ENG-SP19003-R2-TIS-redlines.pdf Markup Summary

Subject: EPC ENG Review
Page Index: 1
Date: 8/17/2020 11:49:10 AM
Author: dsdrice
Color: ■
Layer:
Space:
Page Label: 1

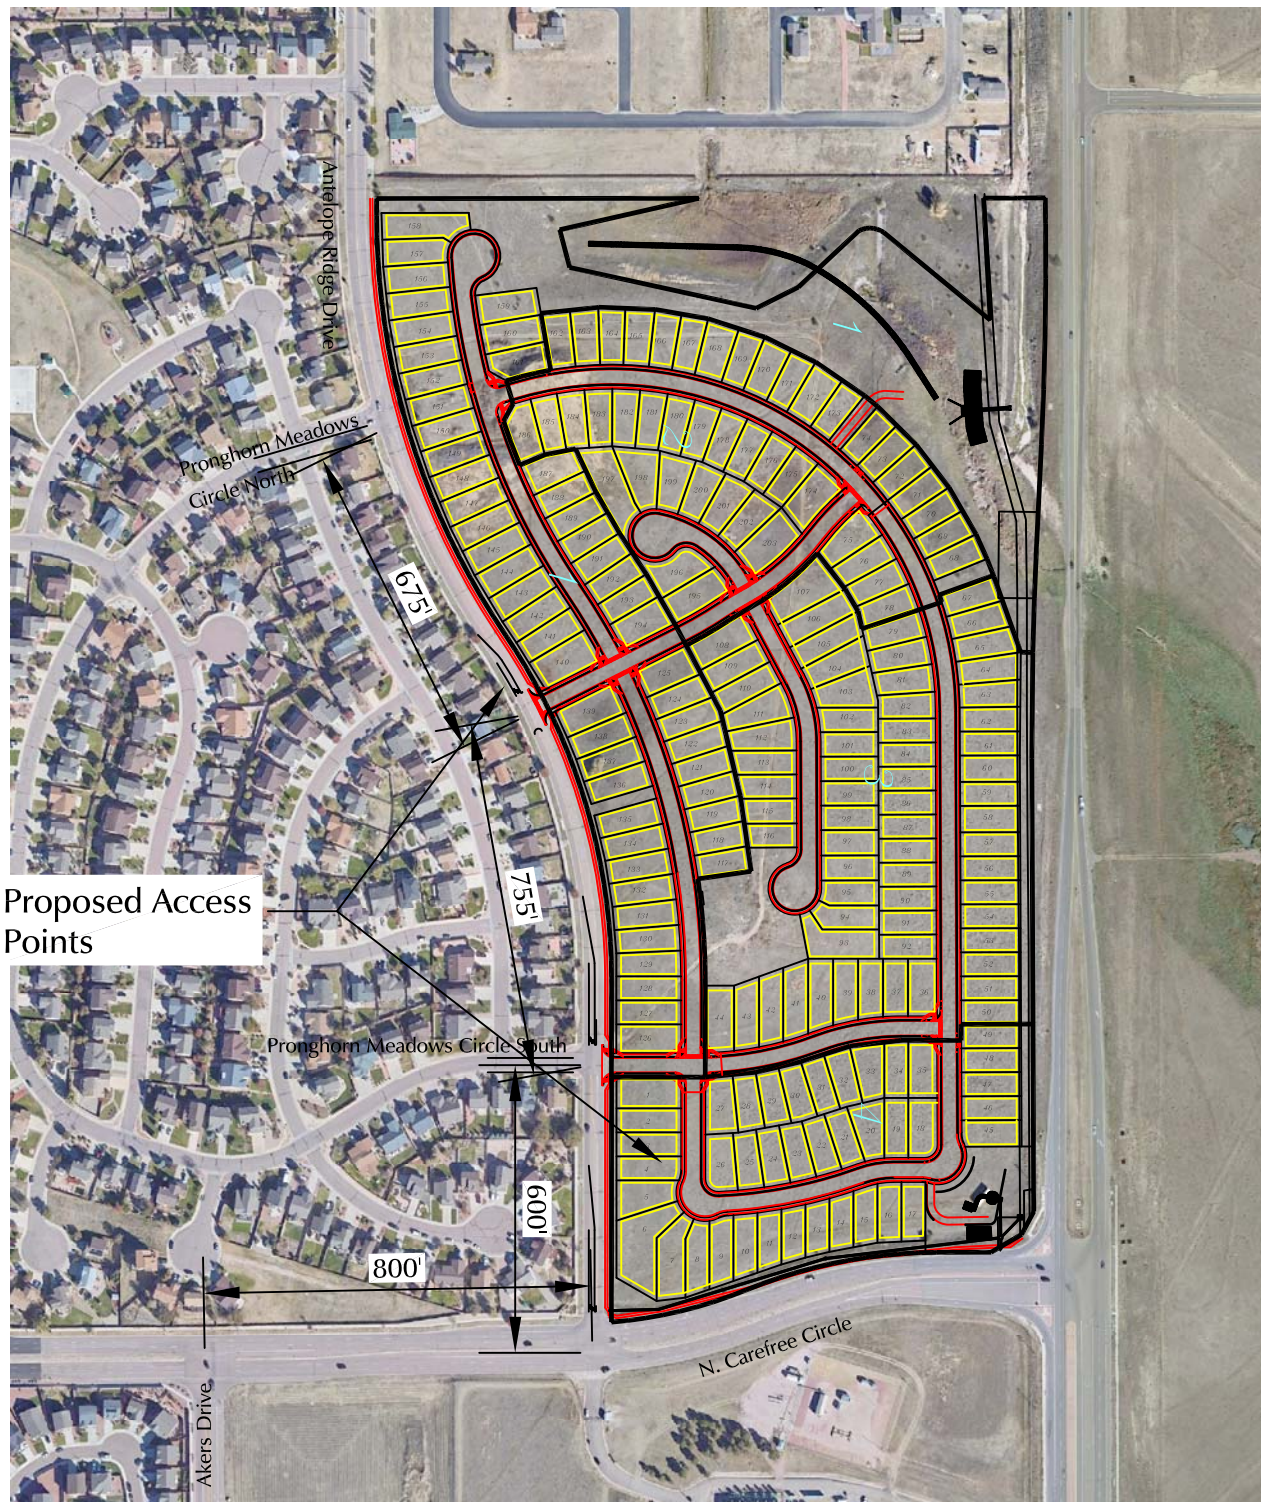
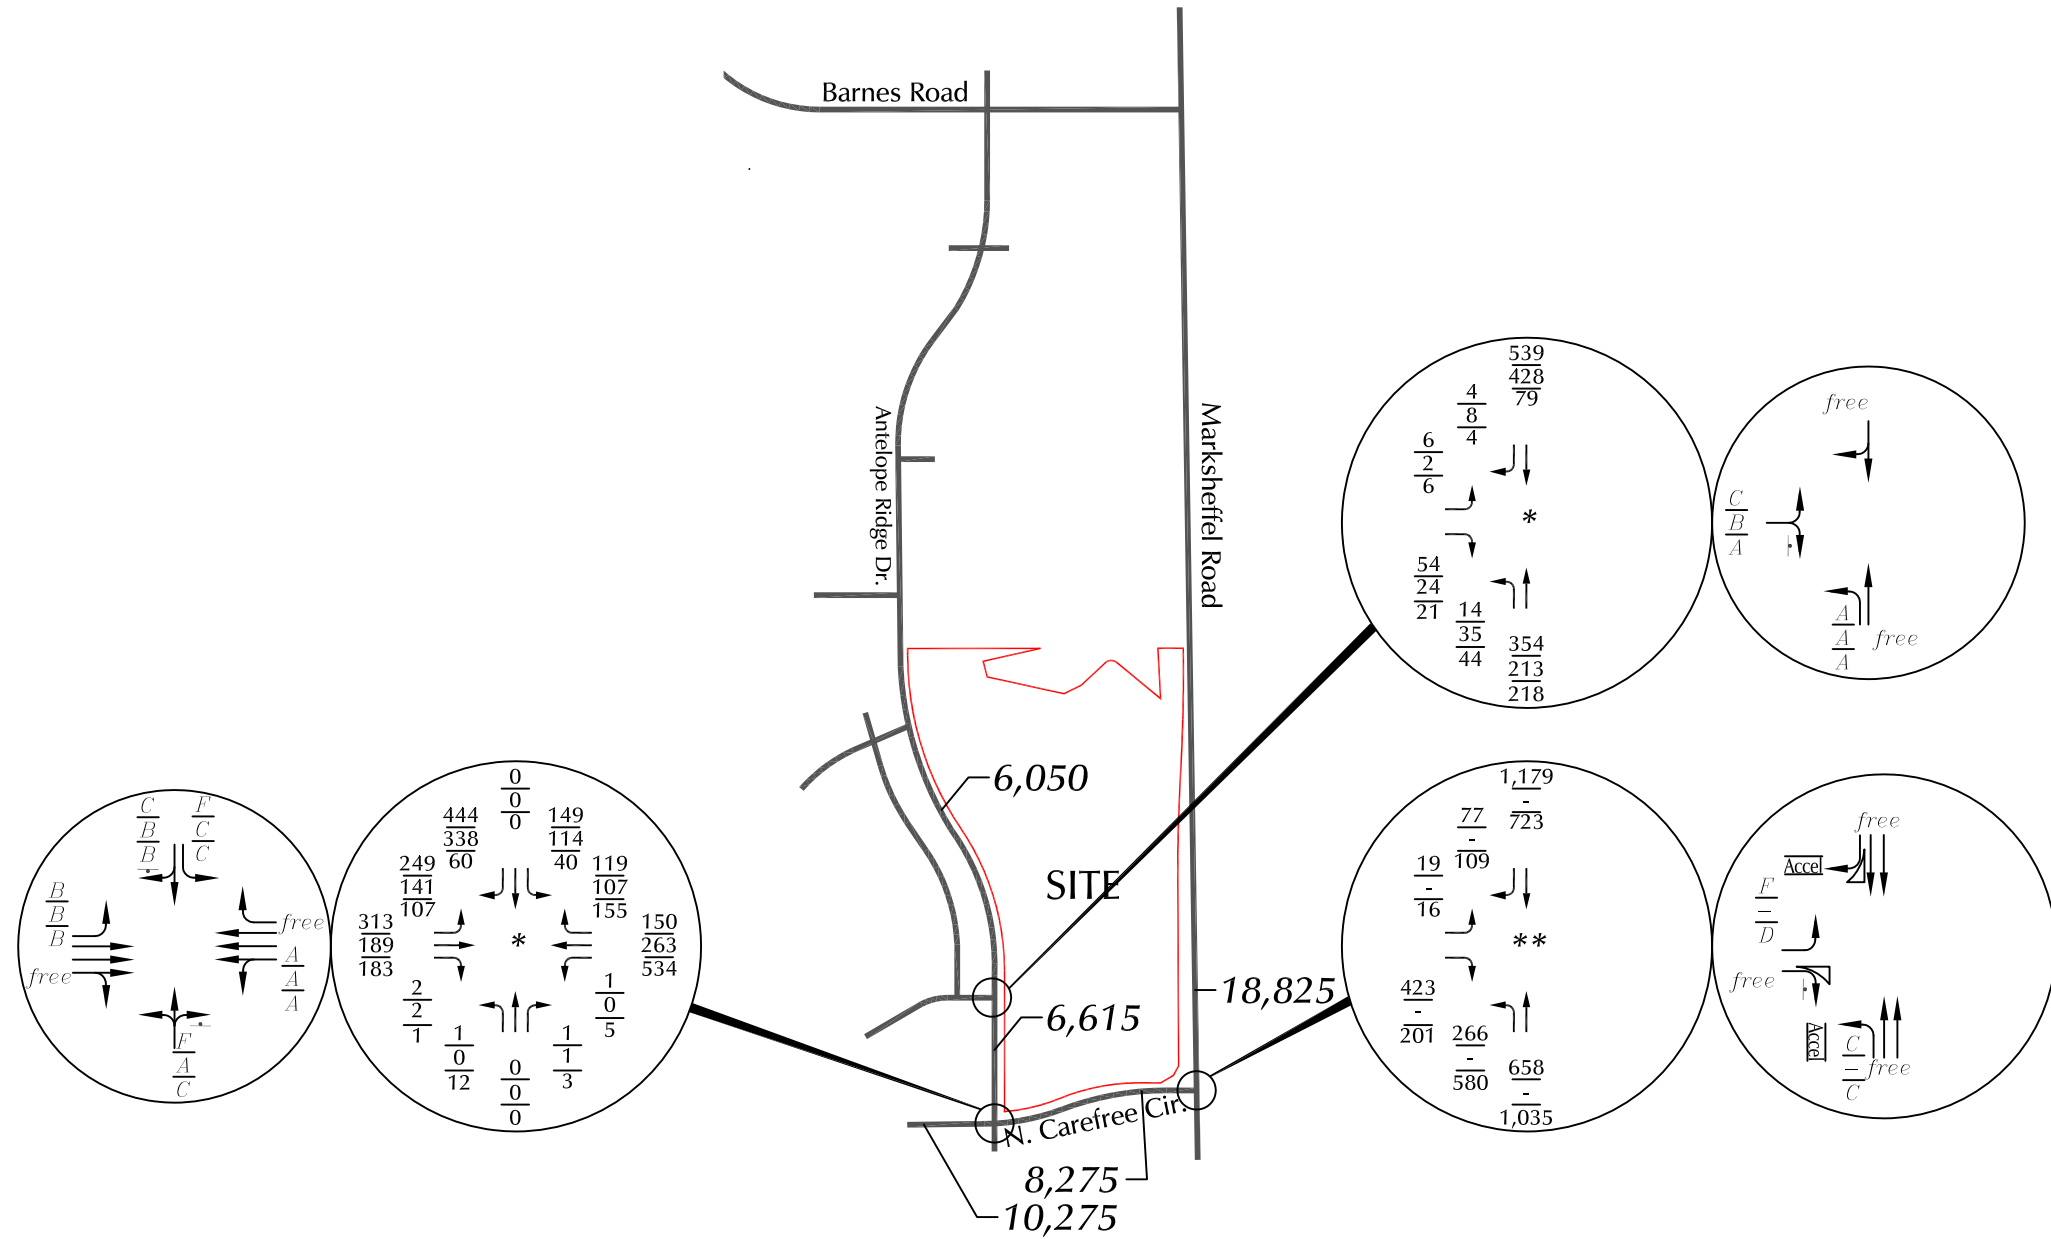
Spot checks showed values on figures didn't match Synchro; please verify and revise as appropriate.
